# **Statement of Common Ground with Wiltshire Bridleways Association**

**May 2026**

**Planning Inspectorate Reference: EN010168**

**Document Reference: EXAM/8.17**

APFP Regulation: 5(2)(a)
Application Doc no.: APP / 6.2
Drawing no.: Figure 13-3

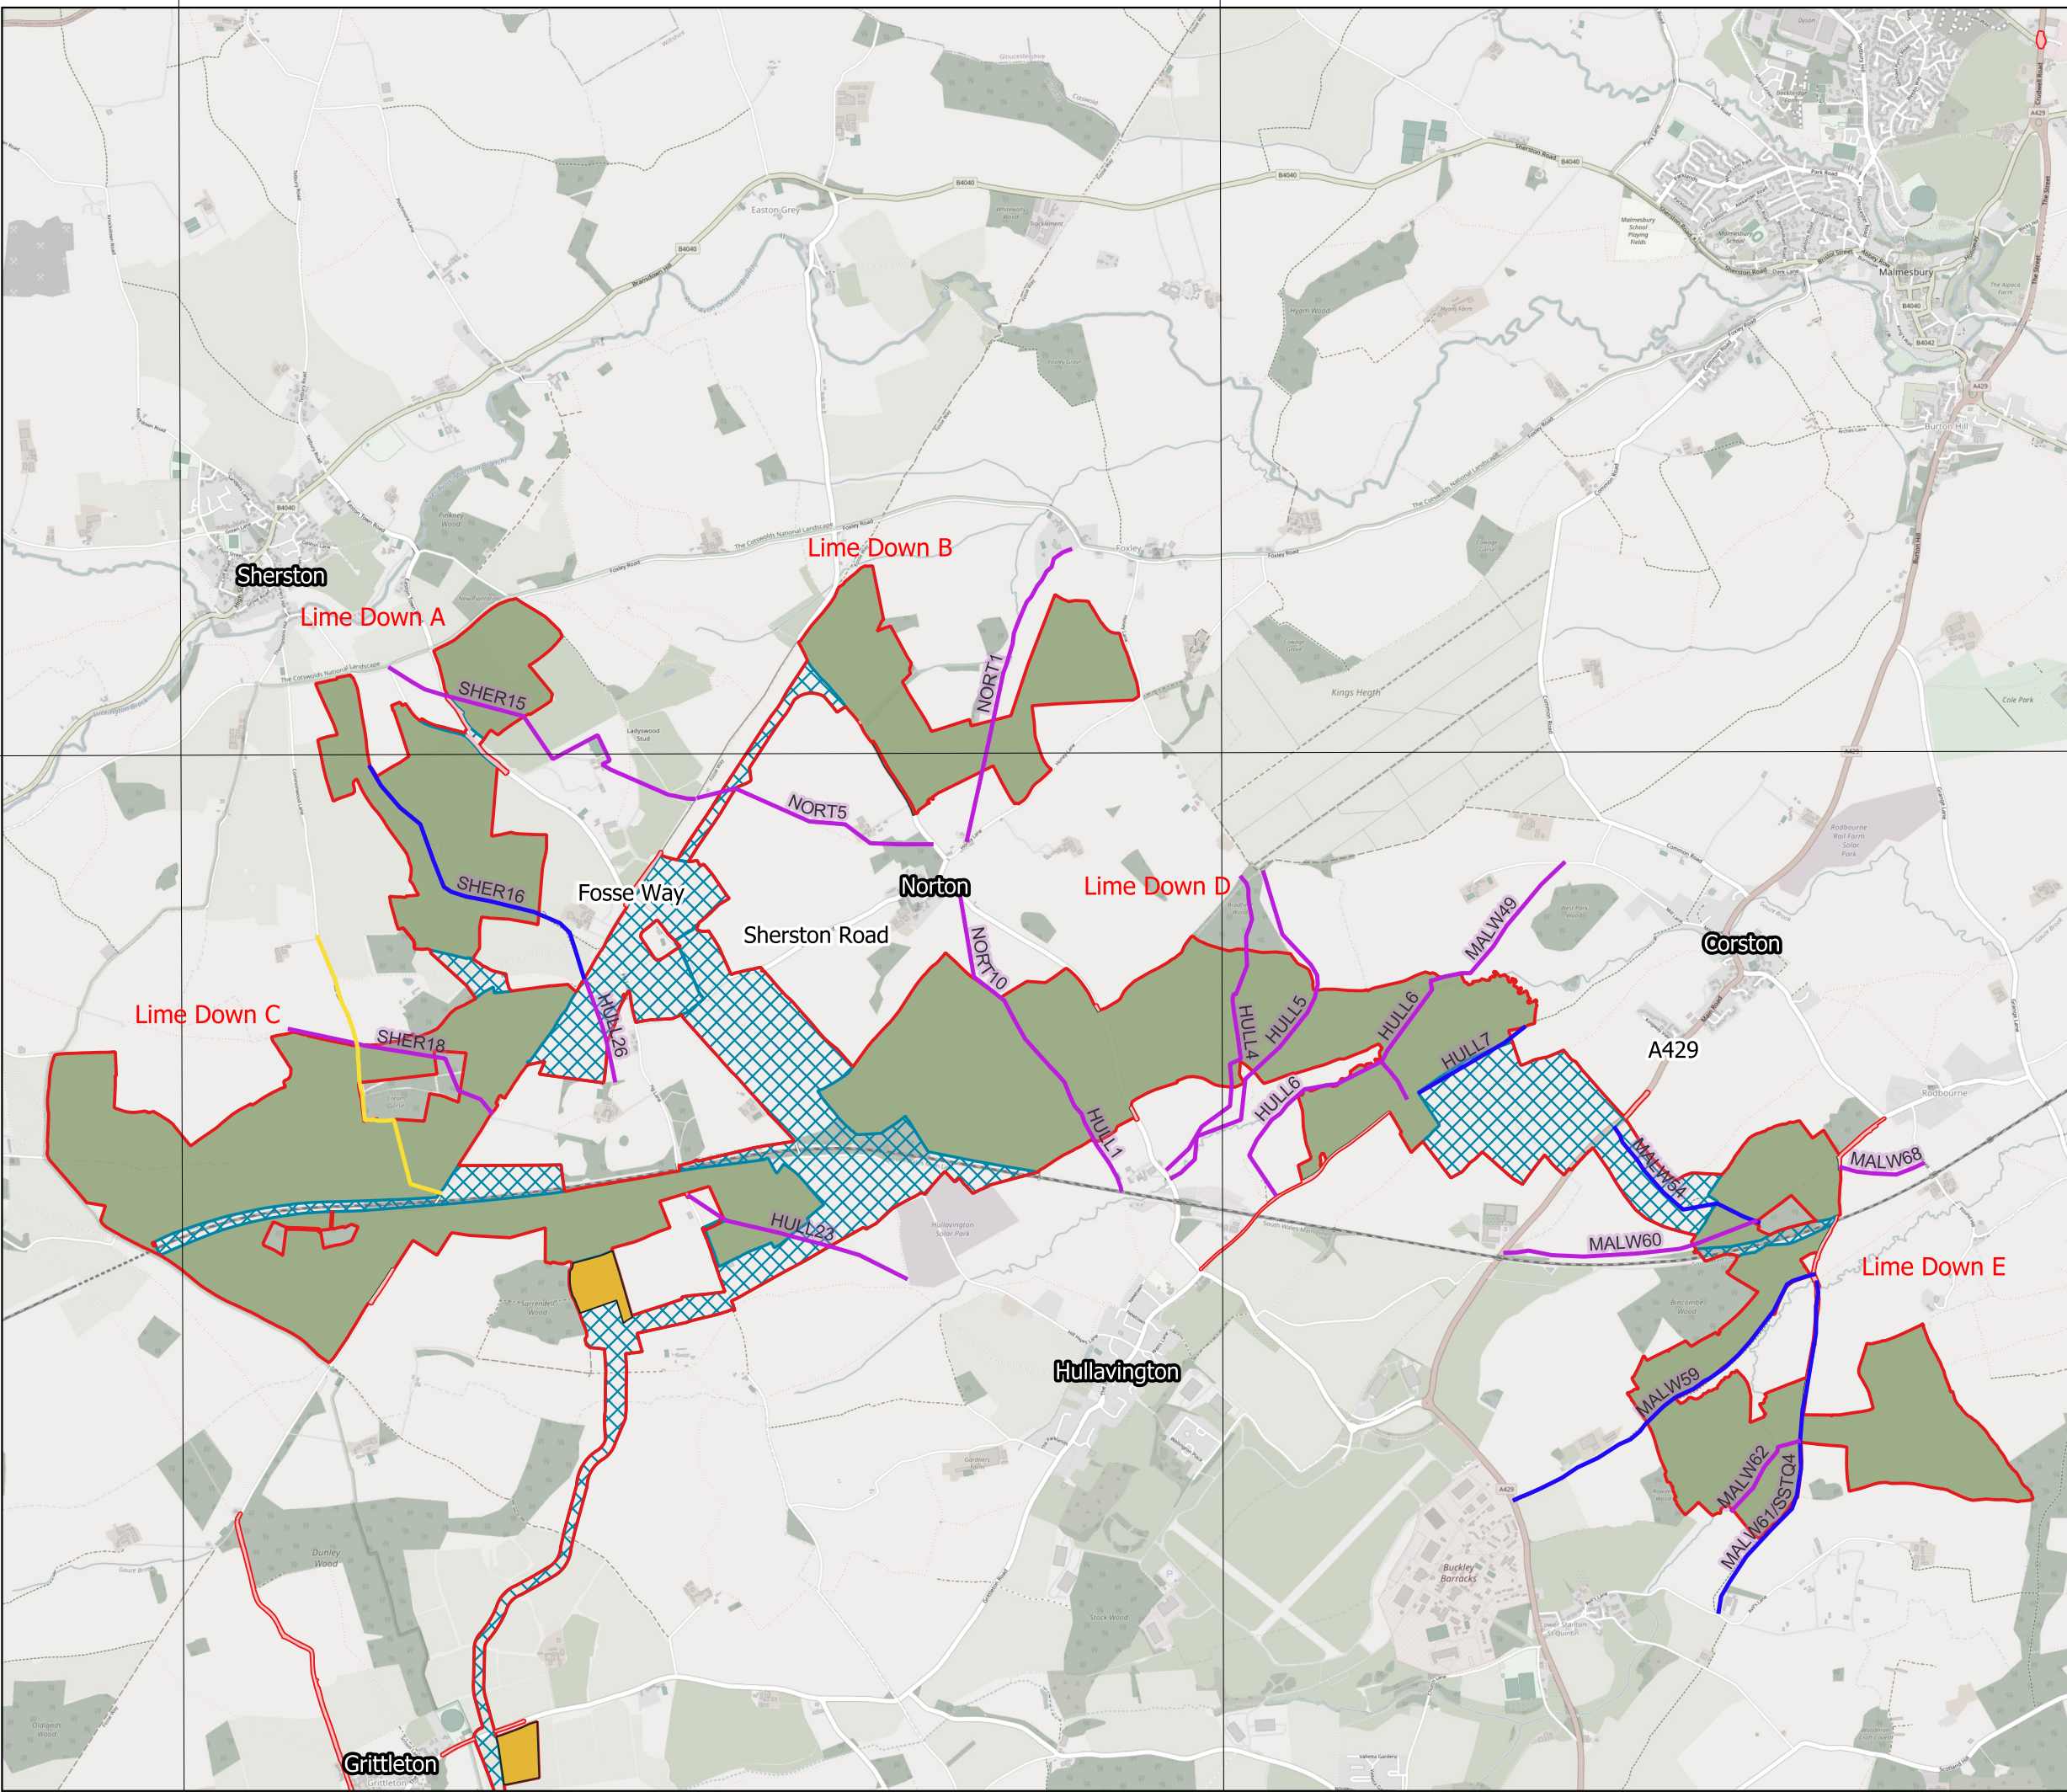
3.1.4	Assessment results - impact on Bridleways within and bordering the application area during construction and operation	<p>WBA is concerned that bridleways SHER14, SHER16, MALW54, MALW59, MALW61, SSTQ4, GSOM9, which becomes SEAG23, would become unusable as a Public Right of Way for the use of equestrians, cyclists and walkers during and after construction if the Lime Down Solar Park were approved.</p> <p>Horse Riders, along with walkers and cyclists, are classed as vulnerable road users and consequently any development that threatens safe off-road riding routes, and which may force riders on to public roads is of major concern.</p>	The Applicant considers that <b>ES Volume 1, Chapter 16: Socio-Economics, Tourism and Recreation [APP-068]</b> and its supporting <b>ES Volume 3, Appendix 16-1: Socio-Economics, Tourism and Recreation: Legislation, Policy, Guidance, and Supporting Information [APP-240]</b> have sufficiently assessed the likely impacts of the Scheme at construction, operation, peak replacement, and decommissioning on all public rights of way, unsurfaced highways, the local highway network, and any permissive routes made known to the Applicant. Equestrian facilities including both	Under Discussion

Reference	Sub-topic	WBA Position	Applicant's Position	Status
		Riders are likely to avoid narrow, enclosed corridors through solar farms, losing enjoyment of off-road routes and open countryside views.	private facilities and business have also been individually assessed. Residual significant adverse effects are only assessed as likely to occur during construction, to bridleway MALW54, the unsurfaced roads in Rodbourne used to access Lime Down E, and the equestrian facilities at Park Farm, Yatton Keynell.  Mitigation measures to protect all PROW users are set out in the <b>Outline Construction Traffic Management Plan (CTMP) [REP1-112]</b> and <b>Outline Public Rights of Way and Permissive Paths Management Plan (PRoWPPMP) [REP1-104]</b> , secured respectively by Requirements 15 and 16 in Schedule 2 to the <b>Draft DCO [REP1-007]</b> .

3.1.5	Assessment results - impact on PROWs outside of the application area during construction and operation	WBA are concerned nearby PROWs may also be affected, extending the impact well beyond the 2,000-acre solar park.	The assessment in <b>ES Volume 1, Chapter 16 Socio-Economics, Tourism and Recreation [APP-068]</b> and the supporting <b>ES Volume 3, Appendix 16 2: Tourism and Recreation Receptor Tables [APP-241]</b> have assessed the likely impacts of the Scheme on a 2 km Zone of Influence surrounding the Scheme,	<b>Under Discussion</b>

LIME DOWN SOLAR PARK
Figure 3-4-1
Lime Down Solar Park - Site A
Landscape and Ecology Mitigation Plan - Revision 3
END10168/APP/6.2
5(2)(a)

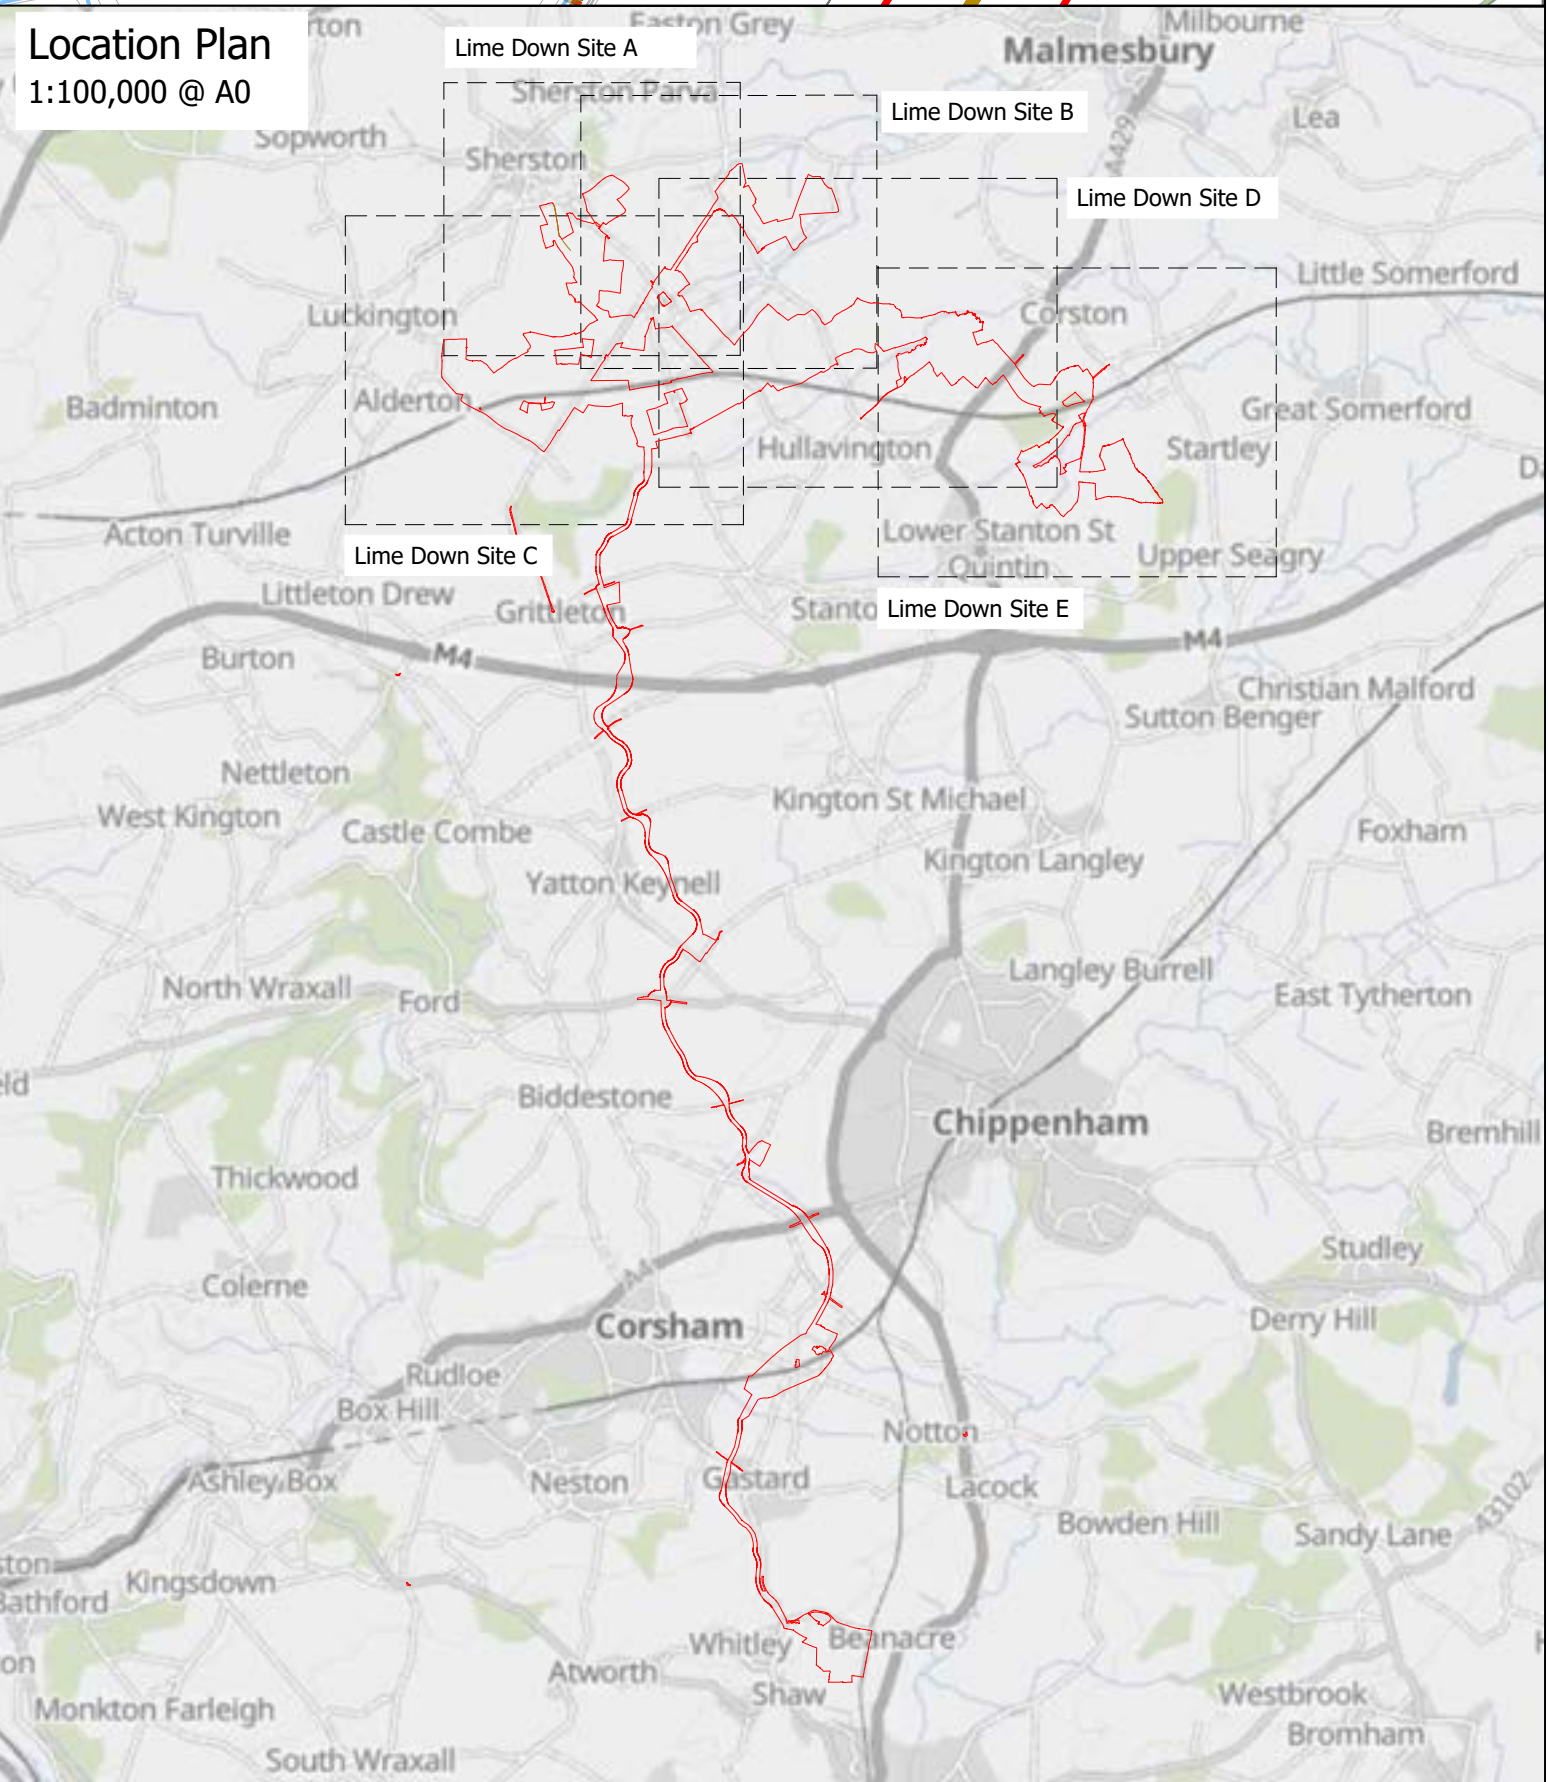
3.1.11	Mitigation - Fencing	Without the below mitigation measures WBA objects to all parts of the development.	A minimum surface width of 3 m is proposed for bridleways, as recommended by guidance from the British Horse Society. However, only groundcover planting will be planted	<b>Under Discussion</b>

Reference	Sub-topic	WBA Position	Applicant's Position	Status
		<ul style="list-style-type: none"> <li>• Maintain minimum width of 4–5m along bridleways/byways.</li> <li>• Use open mesh fencing; avoid intimidating or hazardous fencing (e.g., metal palisades with spikes).</li> <li>• Ensure vegetation and hedges do not narrow usable paths.</li> </ul> <p>It will be very important that the width of the corridors (especially on SHER 16 and the proposed permitted paths through the arrays) are wide enough so horses do not feel trapped or threatened. We note that a minimum of 3 meters is proposed.</p>	<p>immediately alongside PROWs, allowing users to pass at a greater width if required. Where new hedgerow planting is proposed alongside PROWs, this will be planted to maintain a suitable passable width that is to be determined at the detailed design stage. This is shown indicatively on <b>ES Volume 2, Figures 3-4-1 to 3-4 5.2: Landscape and Ecology Mitigation Plan [REP-029 to REP1-032]</b>.</p> <p>The majority of site fencing is to consist of 2 m deer stock fencing set a minimum of 15 m from the centreline of the nearest PROW. Metal palisade fencing is only proposed in locations where there is a danger to life, and so is limited to substation and BESS enclosures. Palisade fencing is not proposed adjacent to PROWs.</p> <p>These principles (including offsets to PROWs, PROW widths, and fencing and PV types), are set out in the <b>Design Principles and Parameters [REP1A-008]</b> and indicatively shown on the <b>ES Volume 2, Figures 3-4-1 to 3-4 5.2: Landscape and Ecology</b></p>

Reference	Sub-topic	WBA Position	Applicant's Position	Status
			<p><b>Mitigation Plan [REP-029 to REP1-032]</b></p> <p>All details of the Scheme are subject to the relevant Requirements in Schedule 2 the <b>Draft DCO [REP1-007]</b>.</p>
